## ENGINEERING VARIANCE REQUEST

| PROJECT INFORMATION:    |                  |
|-------------------------|------------------|
| Project Name:           | Stack Short Plat |

| VARIANCE REQUEST INFORMATION:    |   |
|----------------------------------|---|
| MMC/EDDS Section:                | 3-207(F)  |

**RE: Stack Short Plat  
Variance Request**

ROAD A TYPICAL ROAD SECTION

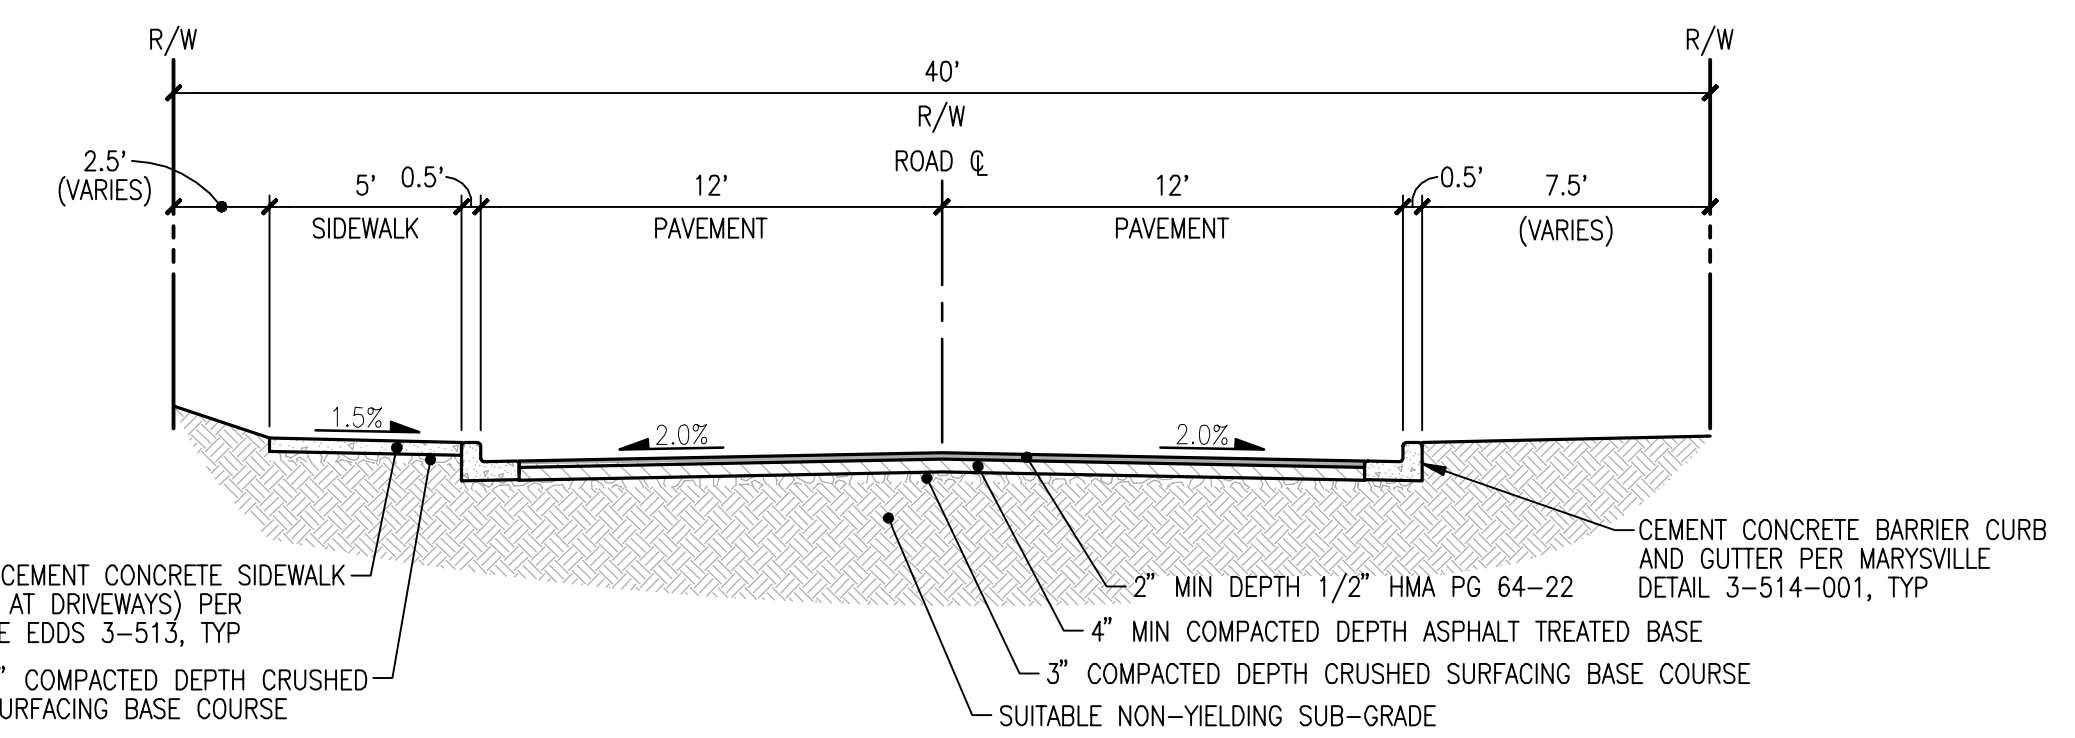
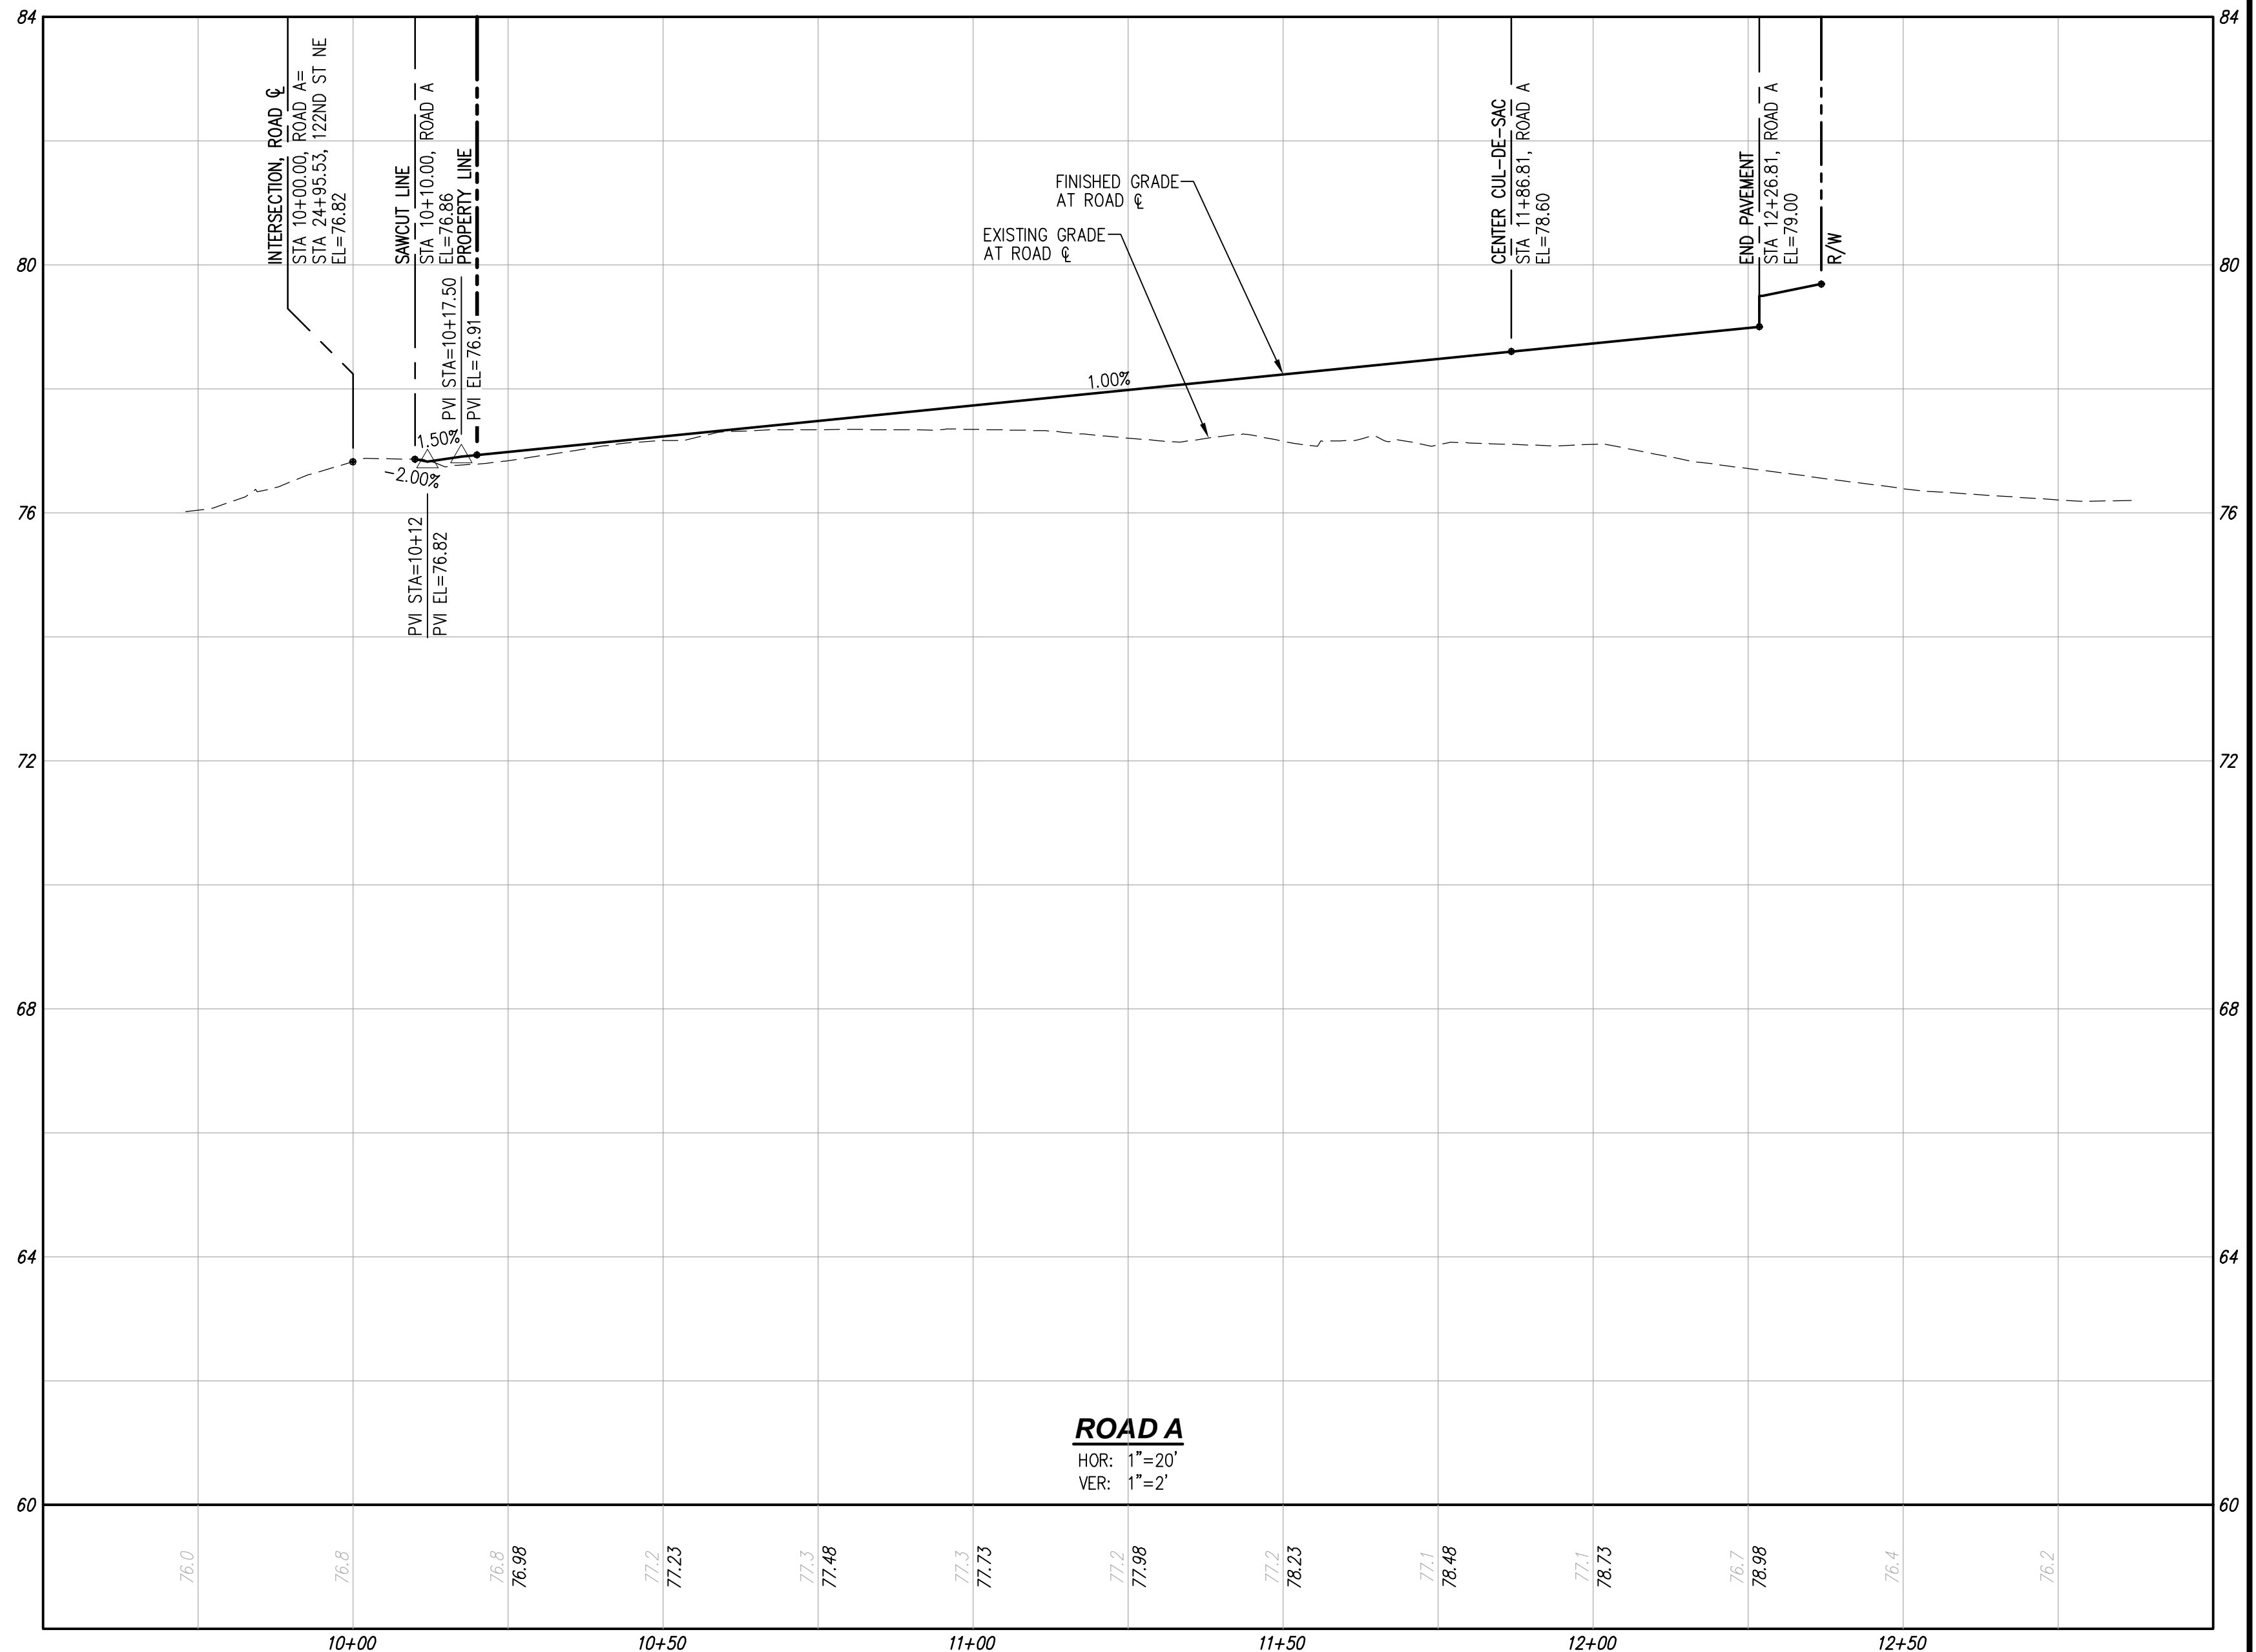
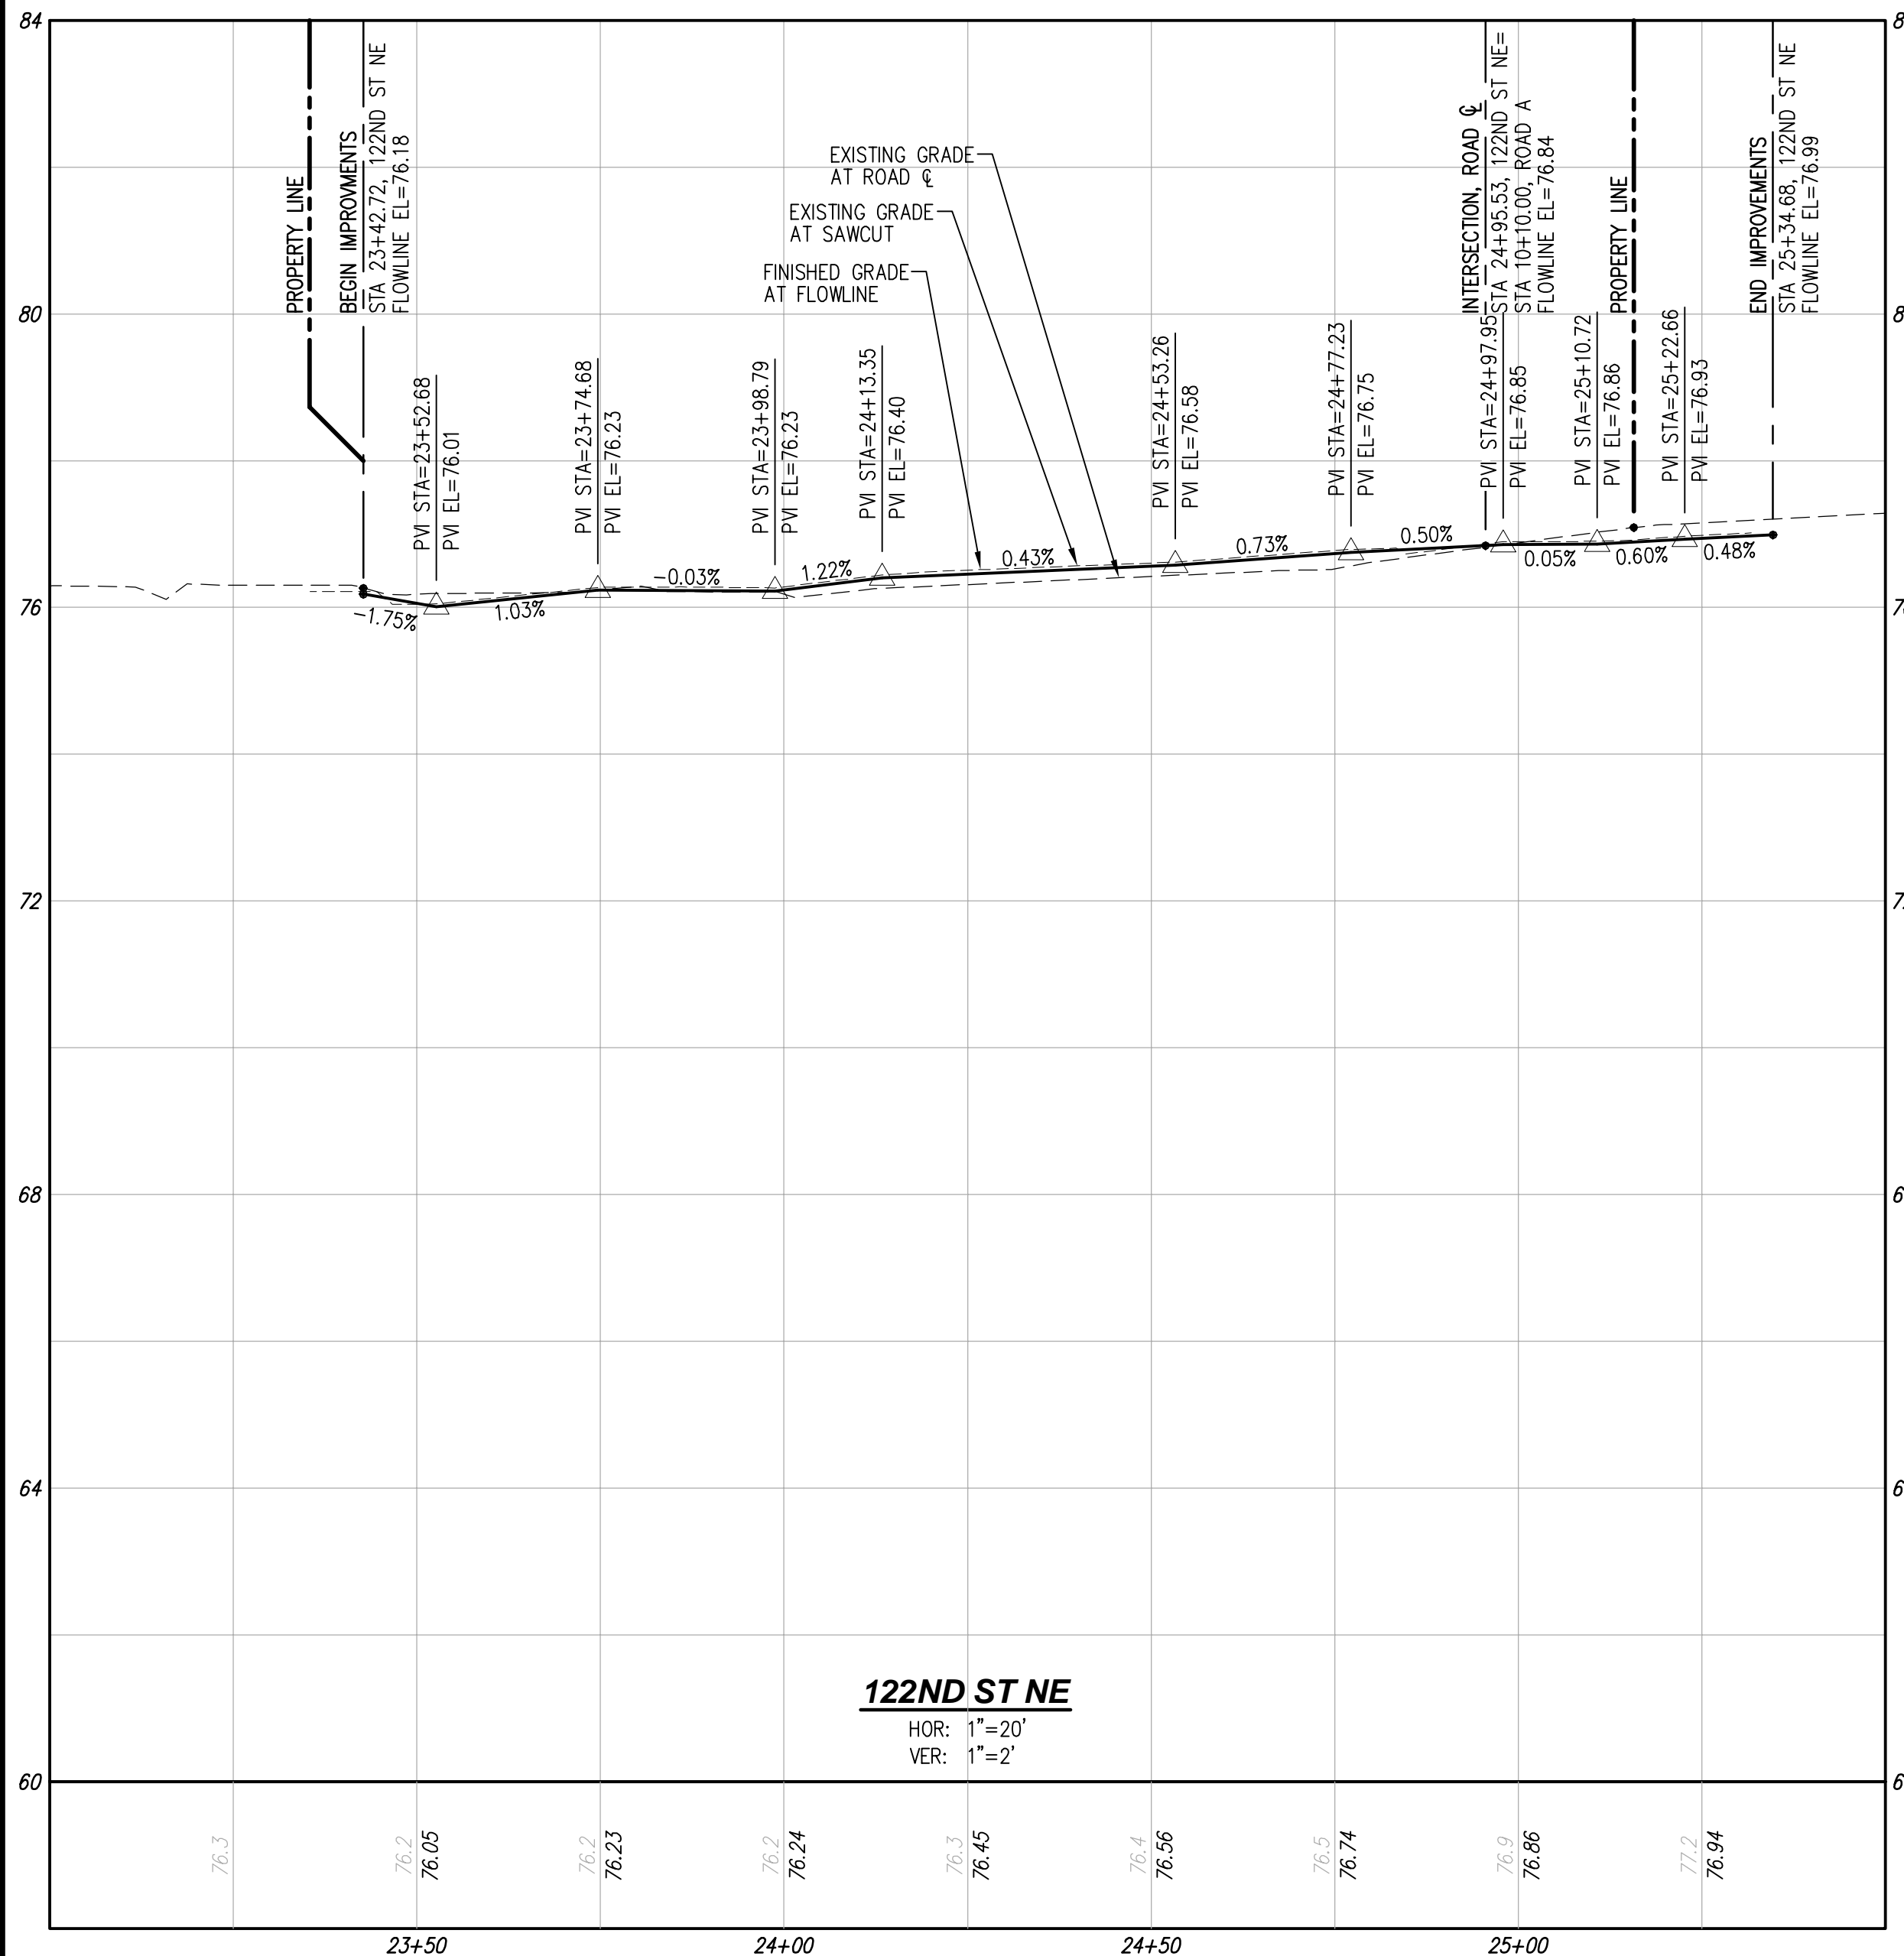
Marysville EDDS 3-207(F) dictates that: Pedestrian walkways shall be provided on all permanent cul-de-sacs to abutting property see Standard Plan 3-207-001.

This project features 5 lots accessing 122nd St NE via new proposed public road and cul-de-sac. Pedestrian access to the site is proposed to be provided as a 5-foot sidewalk along the west side of the street and cul-de-sac to serve the proposed lots which front that portion of the road/cul-de-sac. We are requesting relief from 3-207(F) standard for pedestrian walkways. We find that this configuration is justified by the following:

1. No future development can occur on the east side of Road A, thus no pedestrian access would be taken from that side of the cul-de-sac.
2. Due to site circumstances, this project cannot meet landscape/street tree requirements AND provide sidewalk on east side of the cul-de-sac.
3. The sidewalk on the west side of the cul-de-sac meets safe walk and pedestrian access requirements for the proposed lots.

Additional frontage improvements including curb, drainage infrastructure, and street trees will be installed in the ROW on the east side of the road and cul-de-sac.

Following is additional information on the variance request for the elimination of the sidewalk along the east side of the proposed internal road for the Stack Short Plat.

**Response: The requirement to put sidewalk on the east side of the proposed road on site is an unnecessary hardship in that there are no proposed uses on that side of the road that would use the sidewalk. Therefore, it is not A pedestrian path for all proposed lots is being provided for on the west side of the road.**

The City is in agreement with the provided justification. The project provides sidewalk along the west side of the proposed interior road, providing pedestrian connectivity to the proposed homes. The neighborhood immediately to the east was previously developed, and the rear of the adjacent homes faces the proposed street within the Stack Short Plat. A sidewalk on the east side of the proposed road would not provide pedestrian connectivity to those homes, and therefore is not needed.
